London Luton Airport Expansion

8.45 Holiday Inn Acoustic Barrier - Change Notification

Application Document Ref: TR020001/APP/8.45

Deadline:	Deadline 3
Planning Inspectorate Scheme Reference:	TR020001
Document Reference:	TR020001/APP/8.45
Author:	Luton Rising

**SOUTH ELEVATION SECTION A-A**  
SCALE 1:250

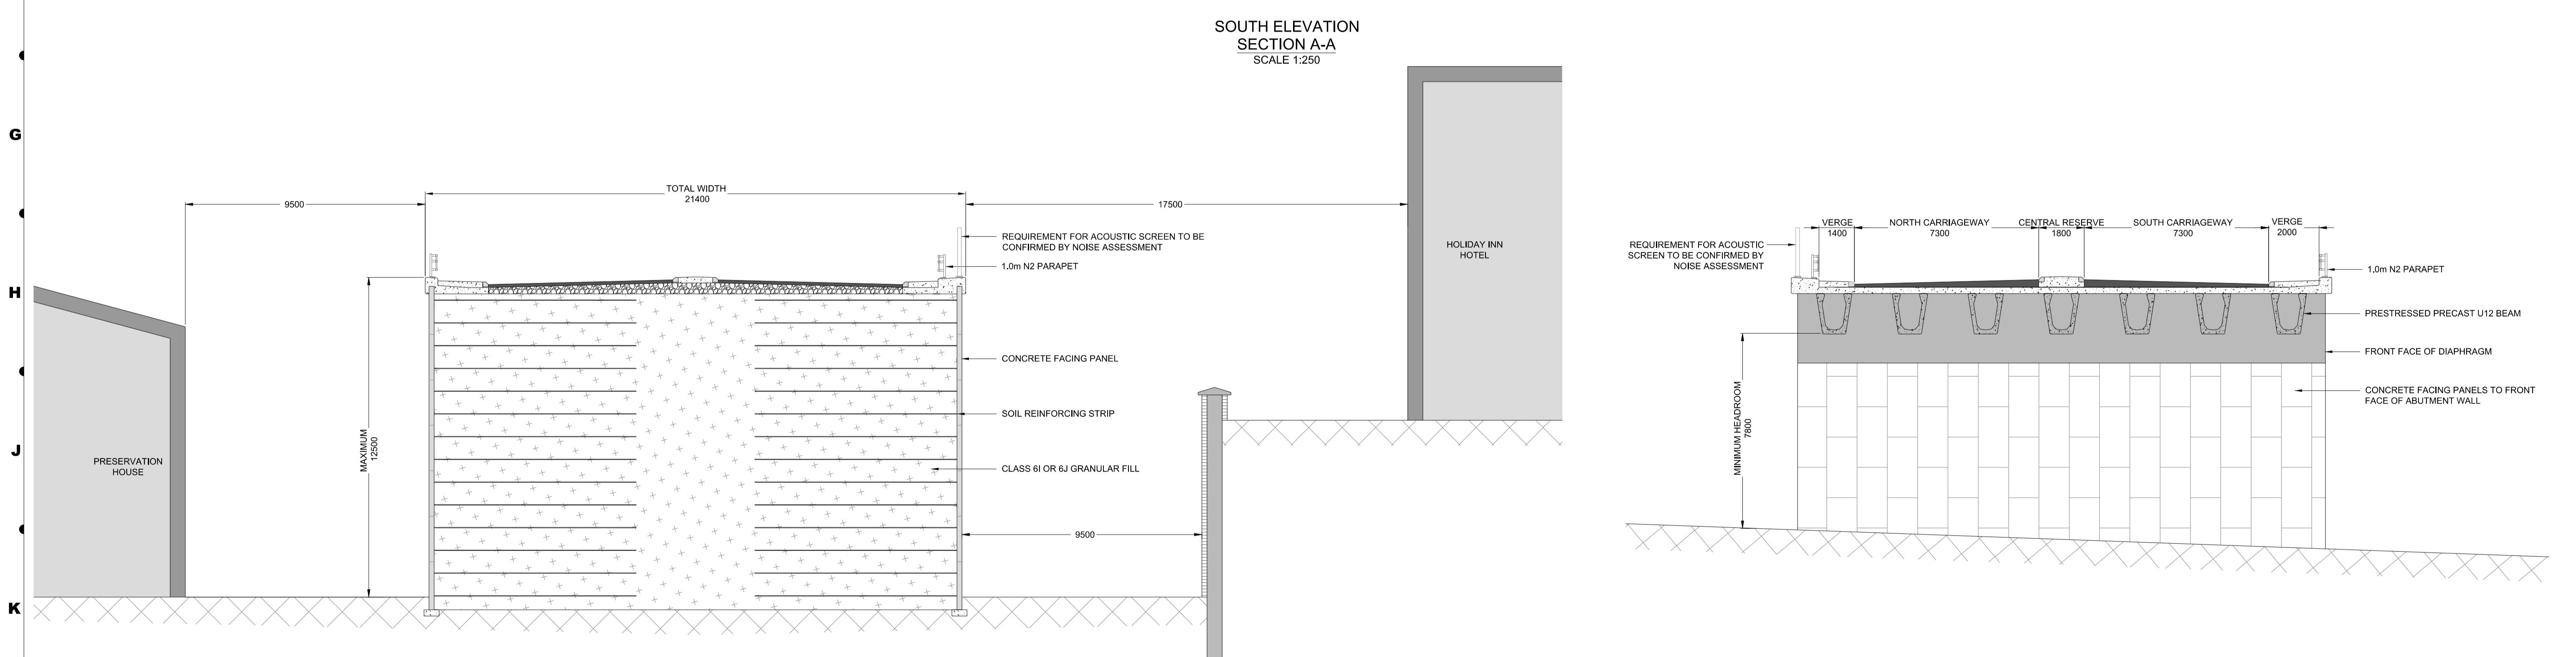
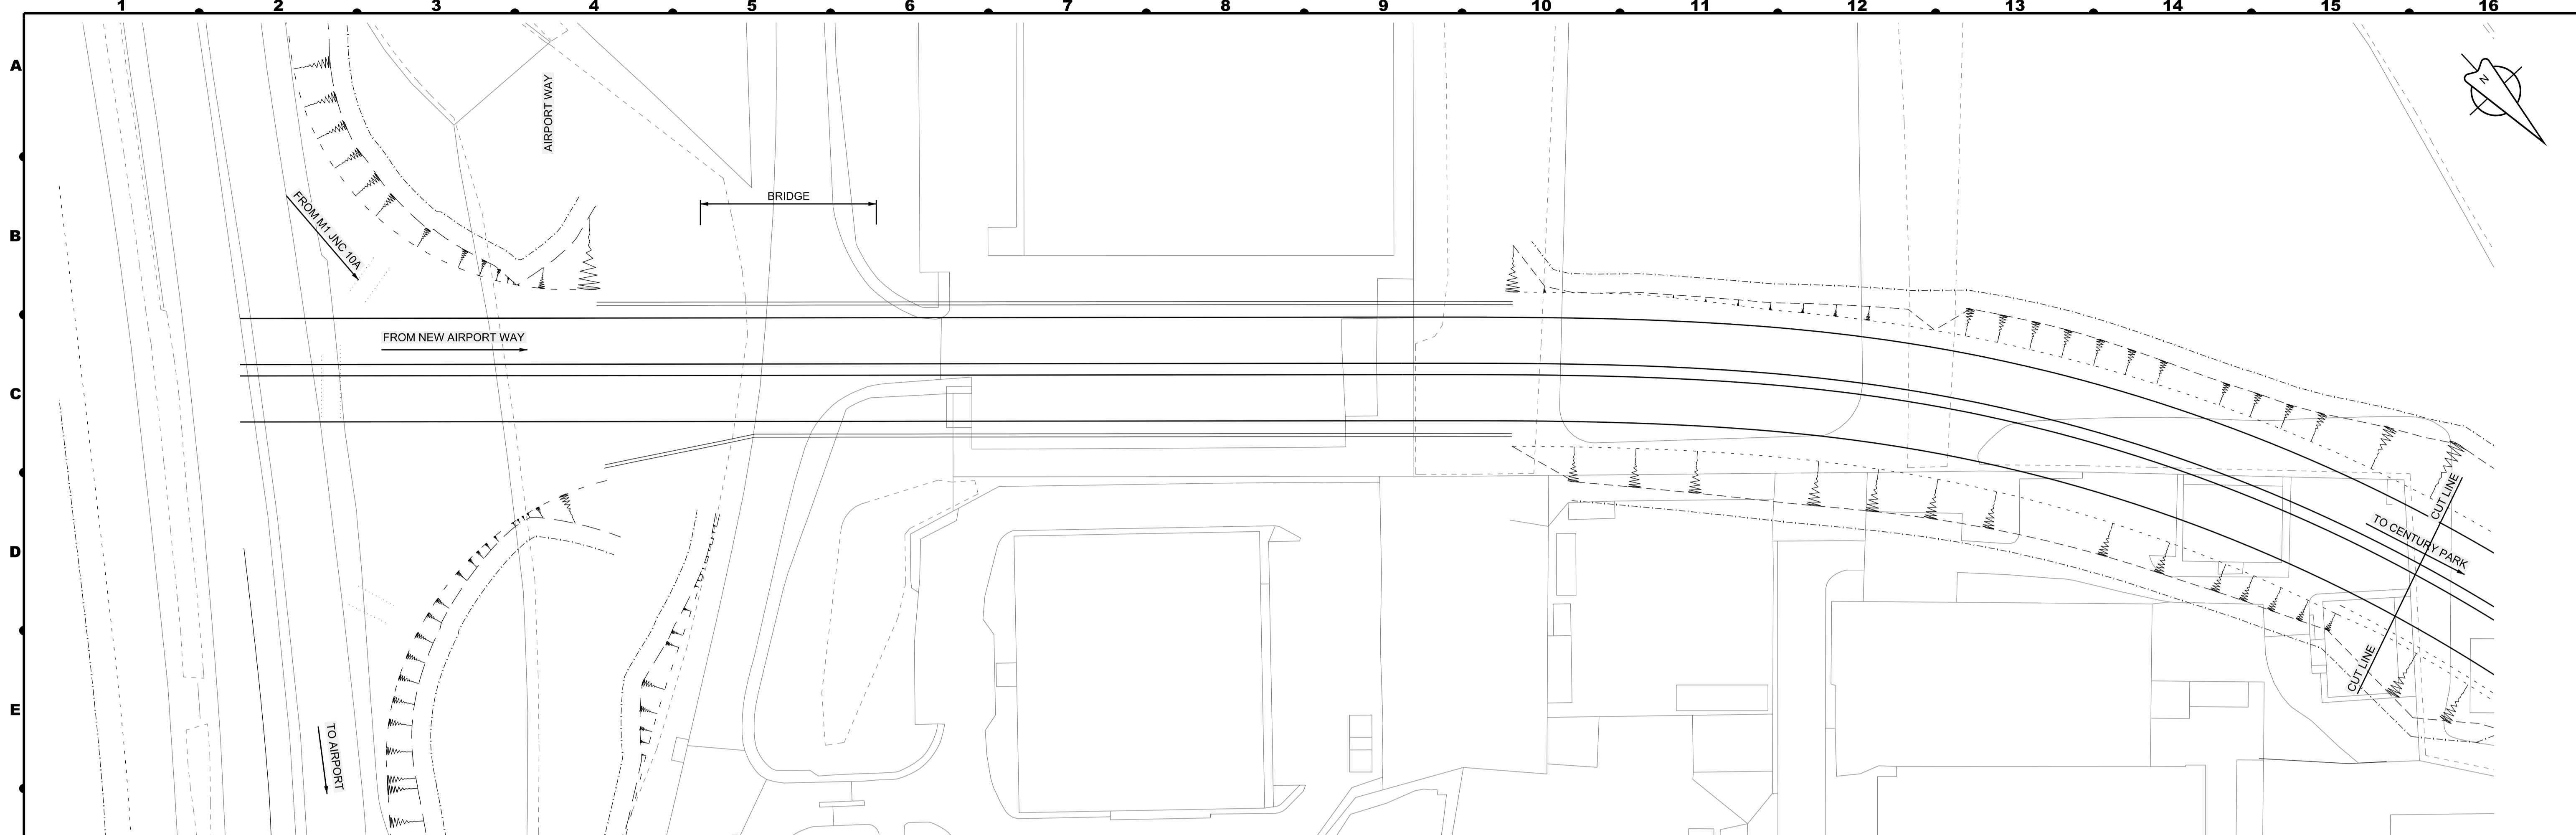
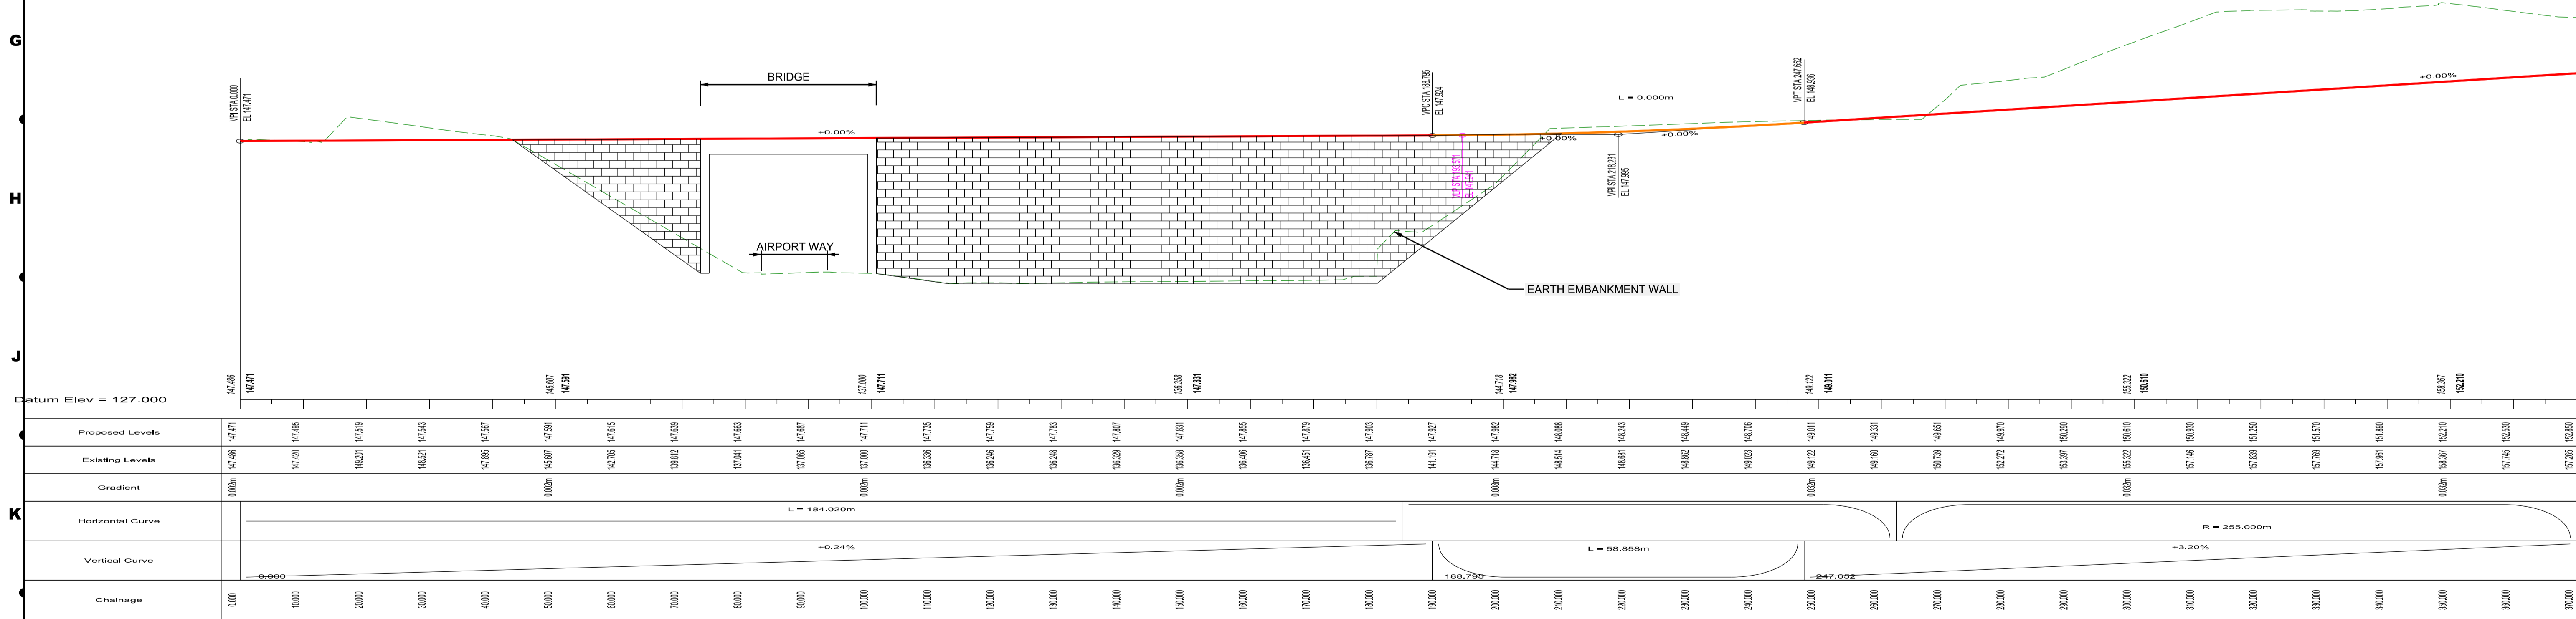
- 2.2.2 Drawing LLADCO-3C-ARP-SFA-HWM-DR-HY-1510 (contained within Appendix A of this document) is based upon the indicative drawing shown in the New Century Park Access Road application (17/02300/EIA), drawing no. D-Q30131-H-0101.

- 2.2.3 The new Airport Access Road will be elevated on a bridge above Airport Way and pass between the Holiday Inn and Preservation House. The proposed acoustic barrier would be positioned on the parapet of the bridge’s northern

side, adjacent to the hotel. In accordance with the details in the extant New Century Park Access Road permission (17/02300/EIA), the barrier would be 132m in length by 2m high. The exact form and structure of the noise barrier would be considered at detailed design stage in accordance with the requirements of the Design Manual for Roads and Bridges (Ref 2.1) using a proprietary system.
